## TREES & CONSTRUCTION MEMO

To: Paul Bosveld  
From: Bob Layton  
CC: Heather Crain, Matt Wittman  
Date: March 31, 2022  
Re: Tree Protection at 38XX W Mercer Way

# TREE RETENTION & TESC PLAN

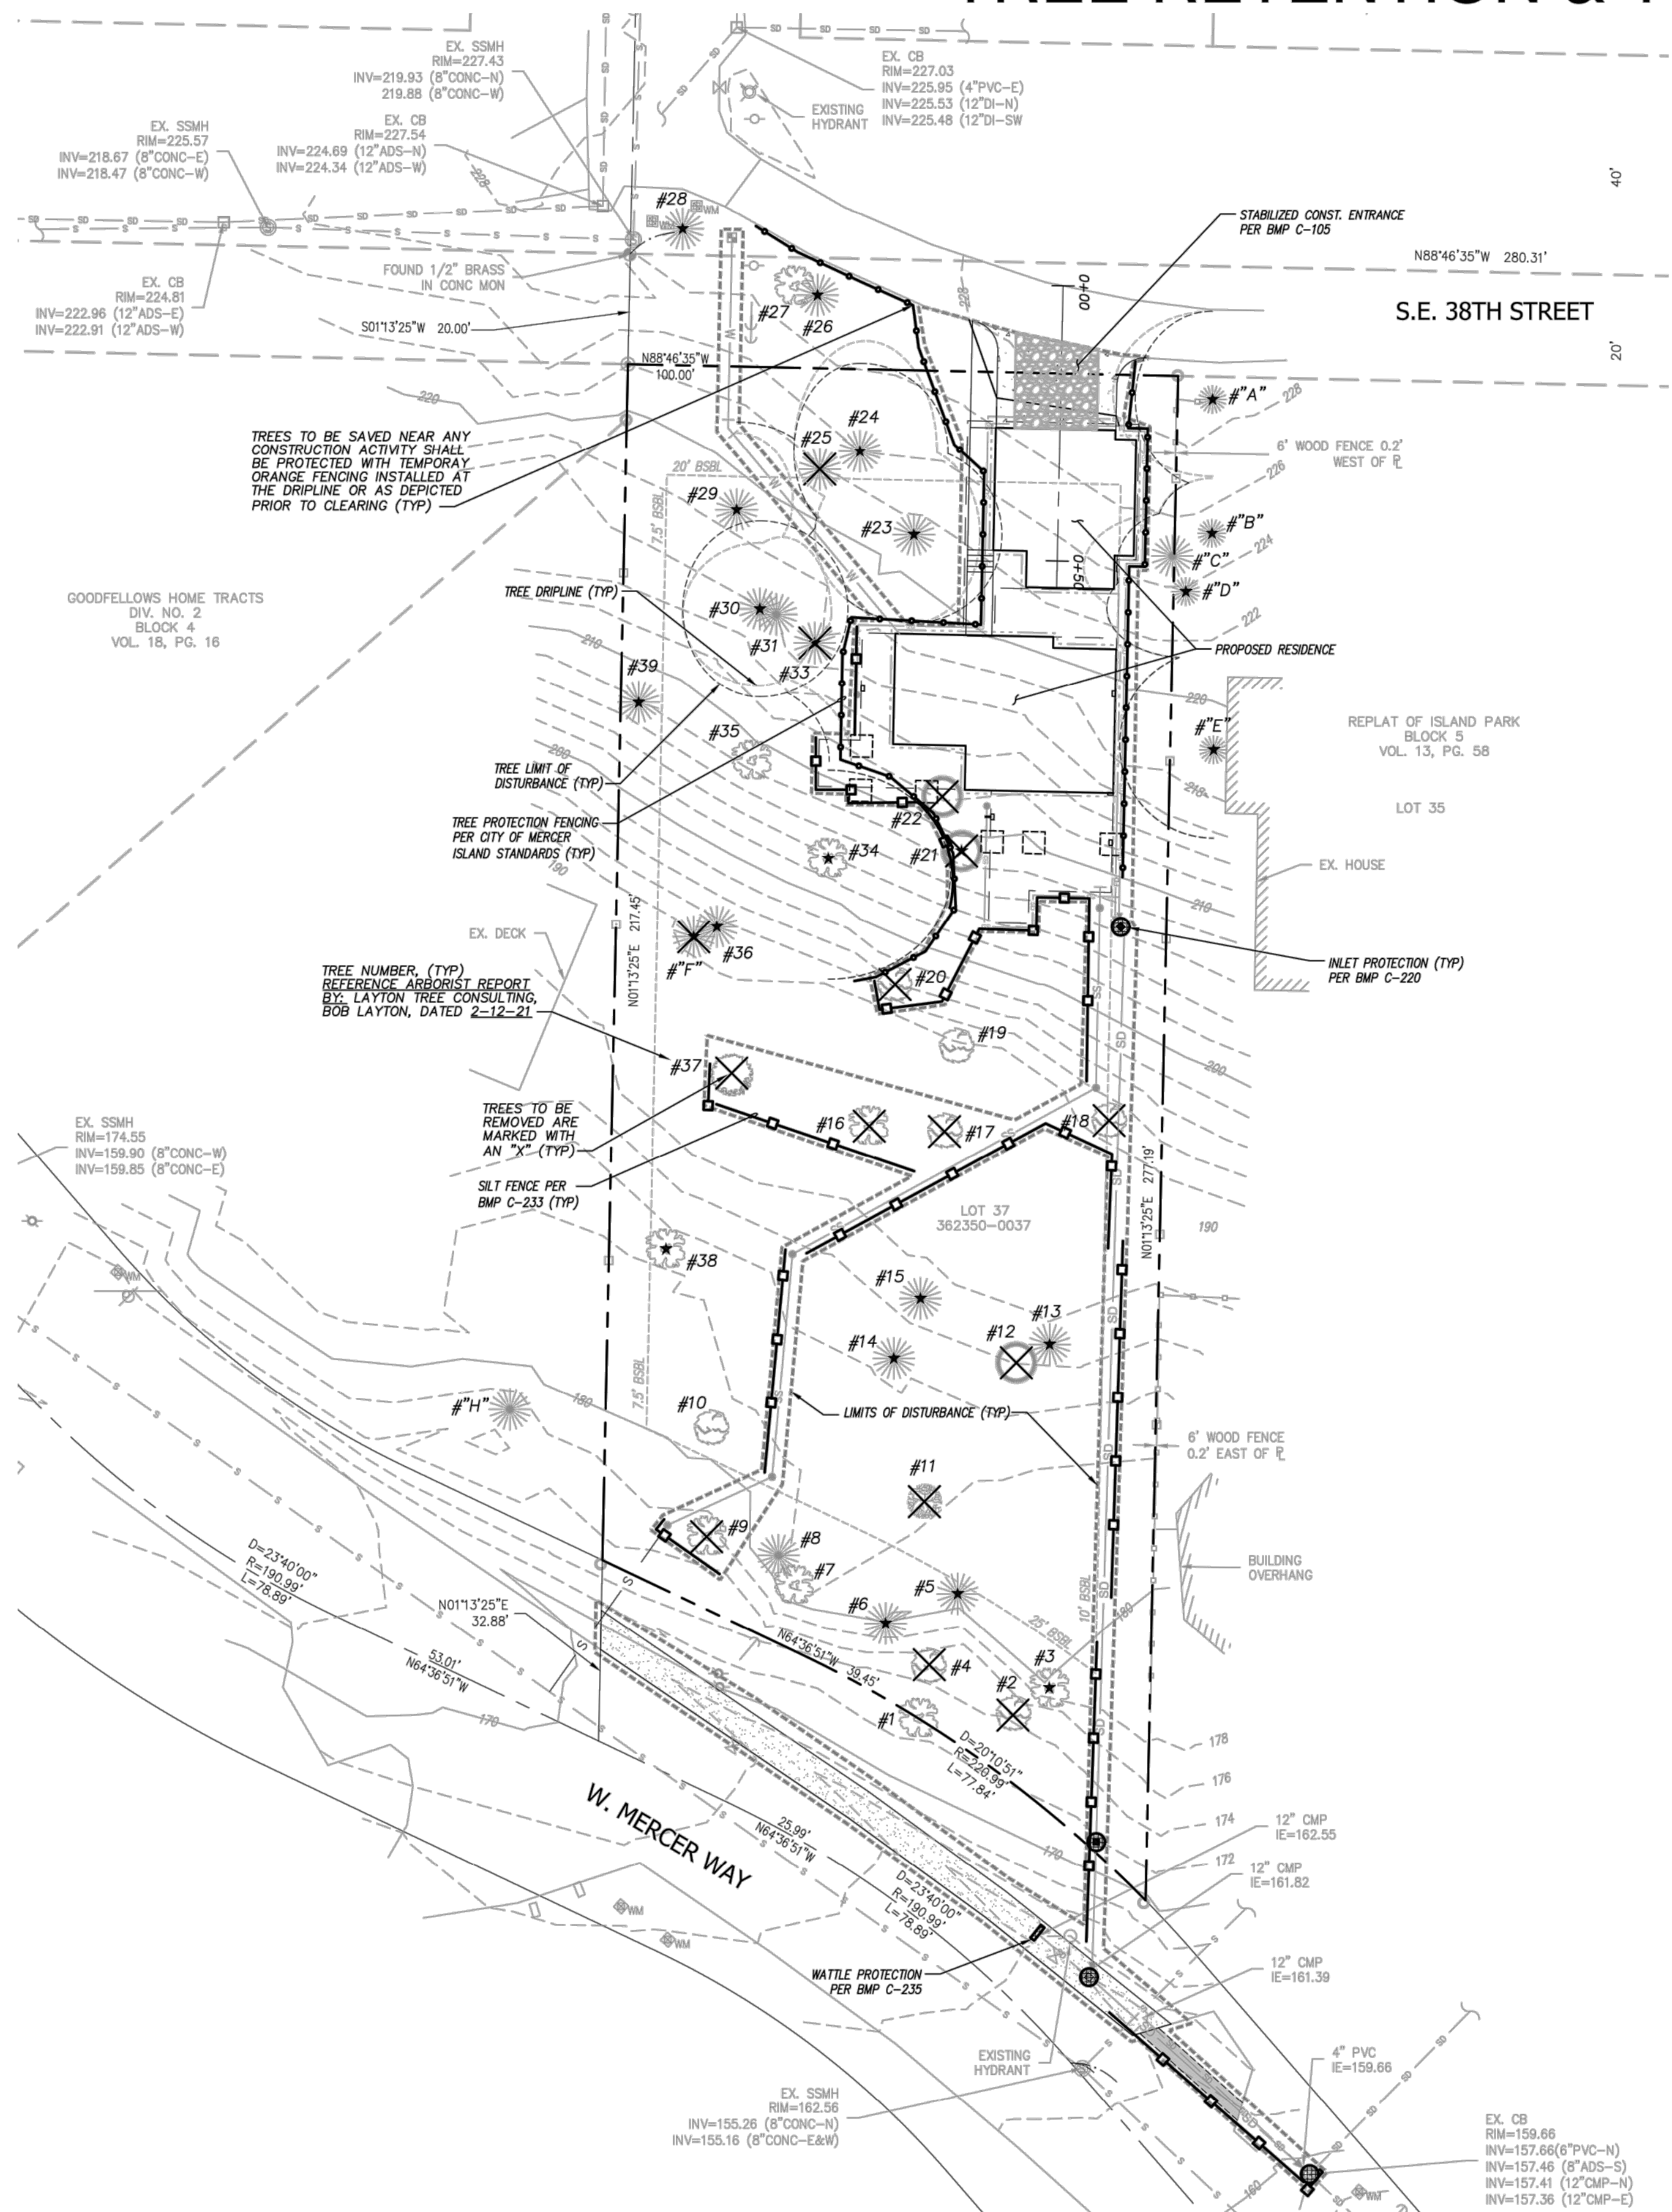
The sewer utility has been designed to avoid the driplines of adjacent trees. The storm drain utility on the south perimeter shall be moved closer to the property line to the farthest extent allowable to reduce the impact to Tree #13 and Tree #3. See the attached copy of the site plan. Slightly move trench north away from Tree #15. The majority of trenching can be accomplished with a tracked mini-excavator. Air-excavate adjacent to Tree #13 if access available or hand-excavate to preserve any roots greater than 2-inches in diameter.

Given the number of exceptional trees to be retained within the vicinity of the water line utility, it is not possible to stay at least 12-feet away from all exceptional trees. The location of the trench will ultimately be field-located to be as far from exceptional trees as possible. The entire length of the water line trench will be air-excavated. All roots greater than 2-inches in diameter will be preserved and the utility/pipe routed beneath them. The trench location on the attached map is shown as 4-feet in width. Realistically, the trench would only need to be a foot to a foot and a half wide to install the plastic waterline.

**1 ENLARGED EXCAVATION PLAN**

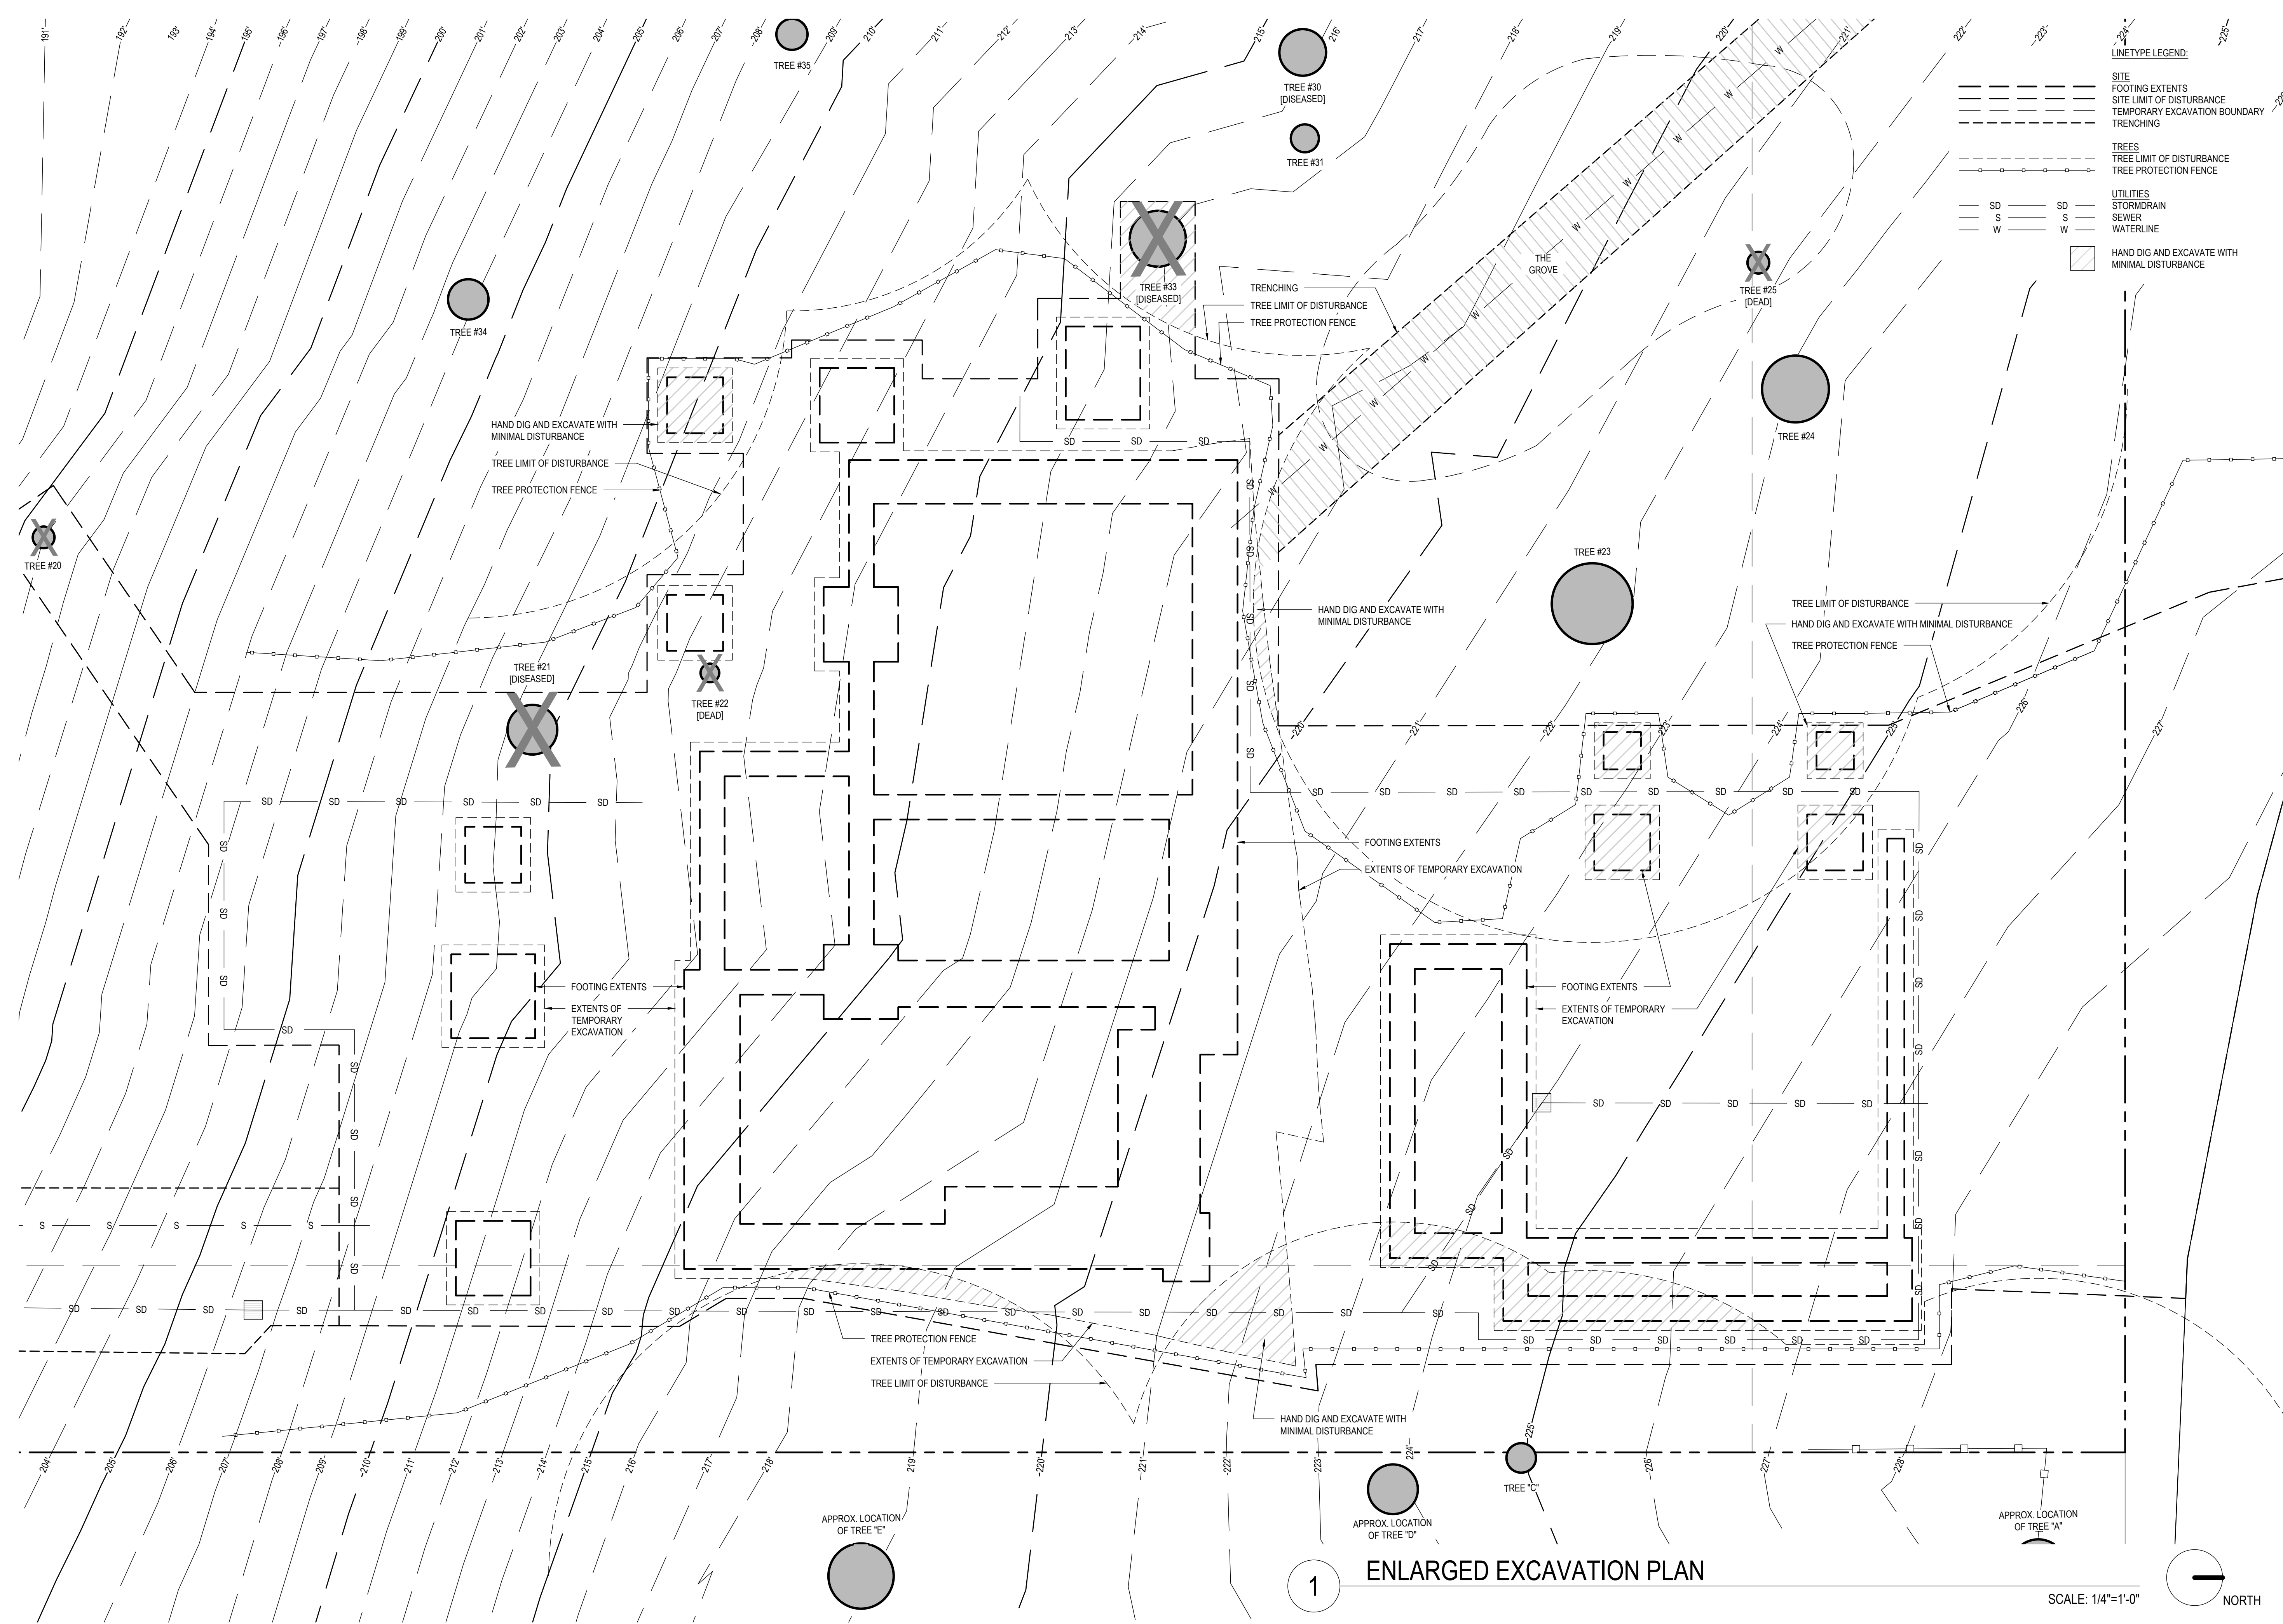
Trees requiring the most attention include Tree #23 and the neighboring Trees B, C and D. These are closest to the proposed site work. The buttress root locations of Tree #23 were air-excavated. See pictures below. The concrete footing proposed directly 4-feet east of the trunk face sits between the two exposed buttress roots which radiate away from the footing location. The footing may need to be slightly shifted north to avoid the south buttress root.

Another trench was air-excavated adjacent to the east property line at the proposed excavation extents. A cluster of +/- 5 structural roots exist directly west of Tree B. See the attached map. These will need to be protected. A continuous concrete footing at this location is not possible.

Footings can be poured at the northeast and southeast corner, and mid-span of the garage to support the floating garage floor. Excavation for a below grade storage compartment west of Trees B and C is not recommended. A smaller storage compartment at the northeast corner of the garage could be excavated out without having any significant impacts on neighboring trees.

It is the intent of the owner to retain Tree #23. 5-feet of clearance between Tree #23 and the proposed improvements is not possible, given the size constraints of the area to be developed. One of concrete footings necessary for the garage and elevated walkway construction has to be within a proximity of the tree, which will not afford the 5-foot clearance. The recommended location of tree protection fencing is shown on the attached map.
